Structural Integrity

April 10, 2013

RTU Replacement and Added Roof Insulation
551 Congress Street
Portland, Maine
Structural Integrity Job: #13-0056

Date: 02 May 2013  
Scale: AS NOTED  
**PROPOSED ROOF PLAN**

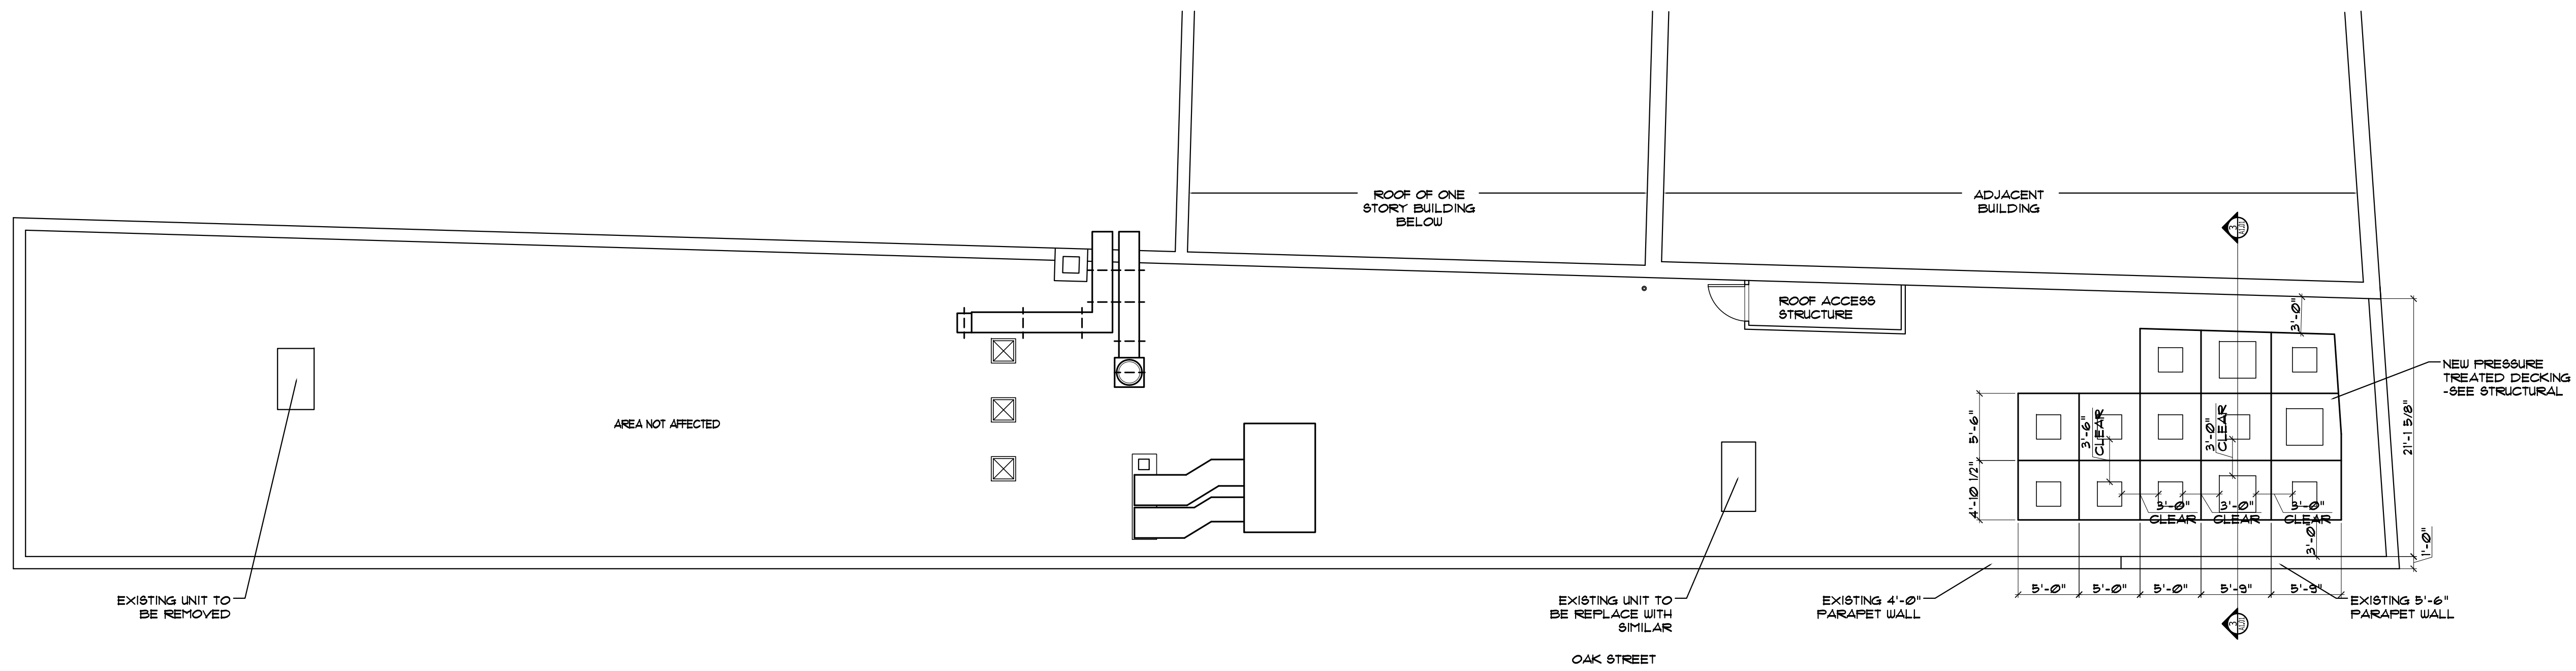
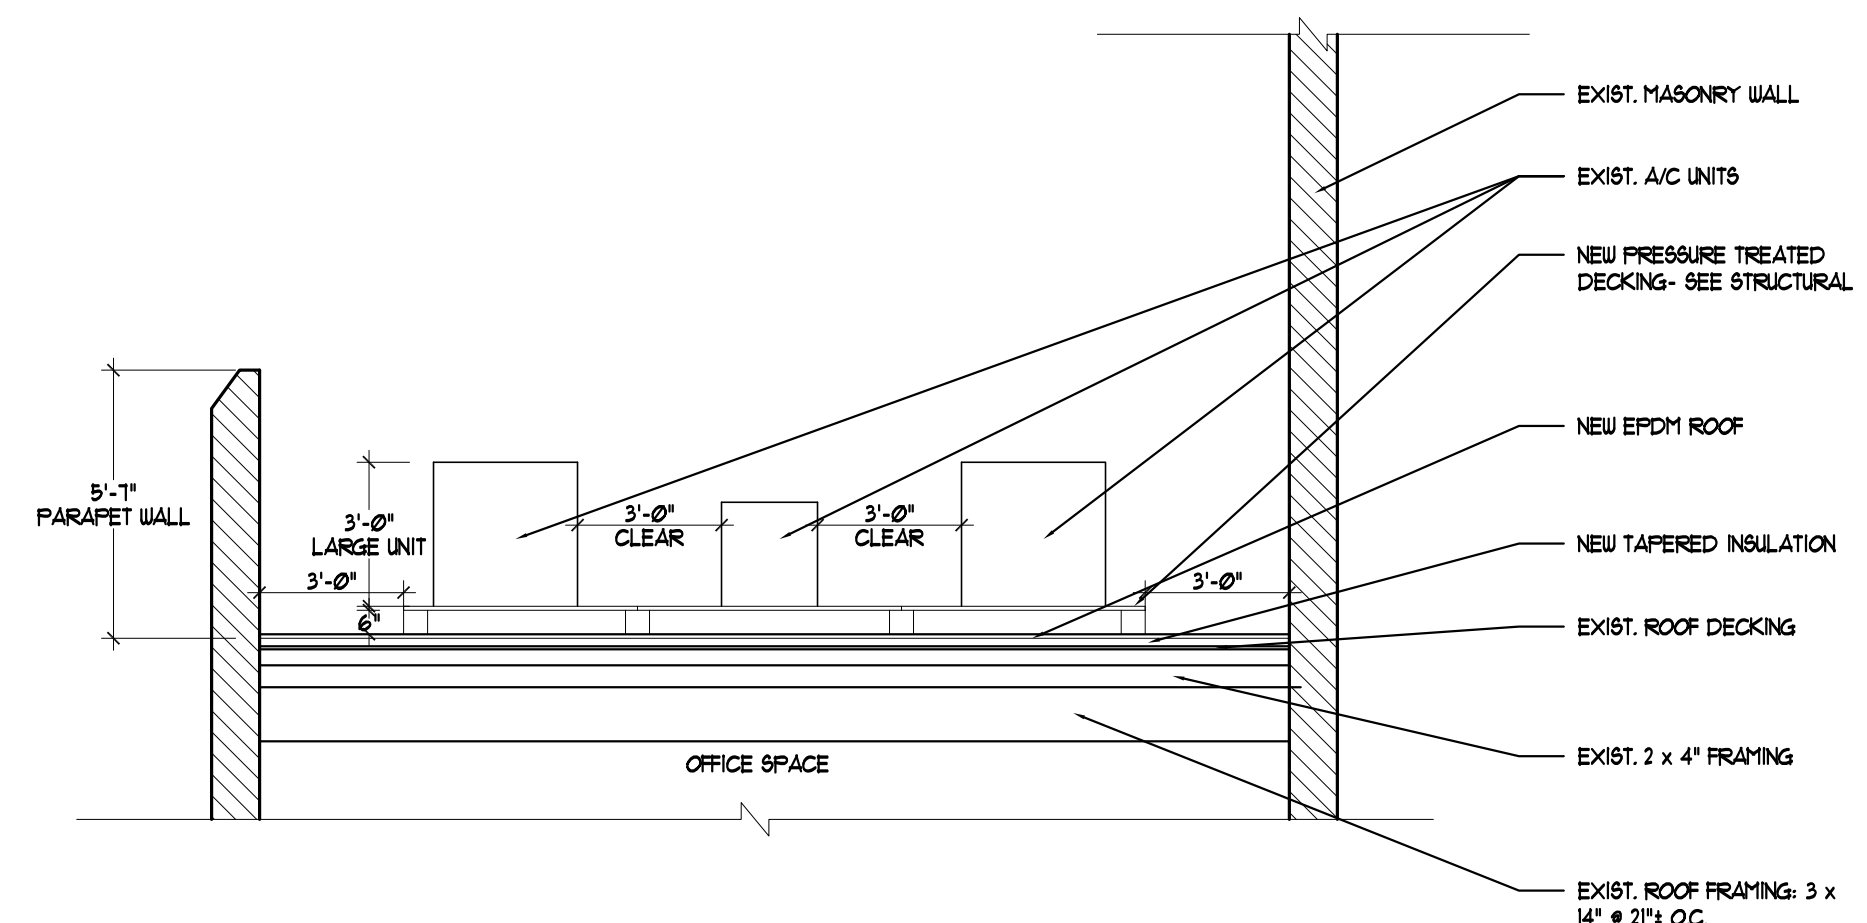
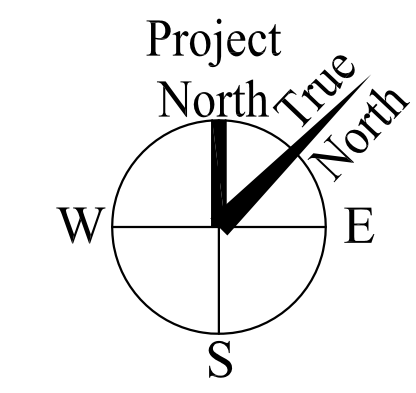
The existing roof is constructed with historic sawn rafters, 2 3/4" x 13 1/2" min. at up to 22" on center supported on pockets in the existing brick masonry walls. Based on my calculation I have found the existing rafters are suitable to support the code imposed loads with the following conditions:

1. The roof should be kept in service, as-is, without a hung ceiling.
2. It is also important that any insulation added as part of the re-roofing project be limited to an R-24 assembly, maximum.
3. New steel angle supports, L5x3 1/2" x 1/4" must be installed at the joist bearing along the Oak Street side of the building per the attached sketch, 1/S-2.

I have also reviewed the location and installation of the Replacement RTU that is to be installed on the existing curb closest to Congress Street and found the framing supporting the RTU to be adequate.
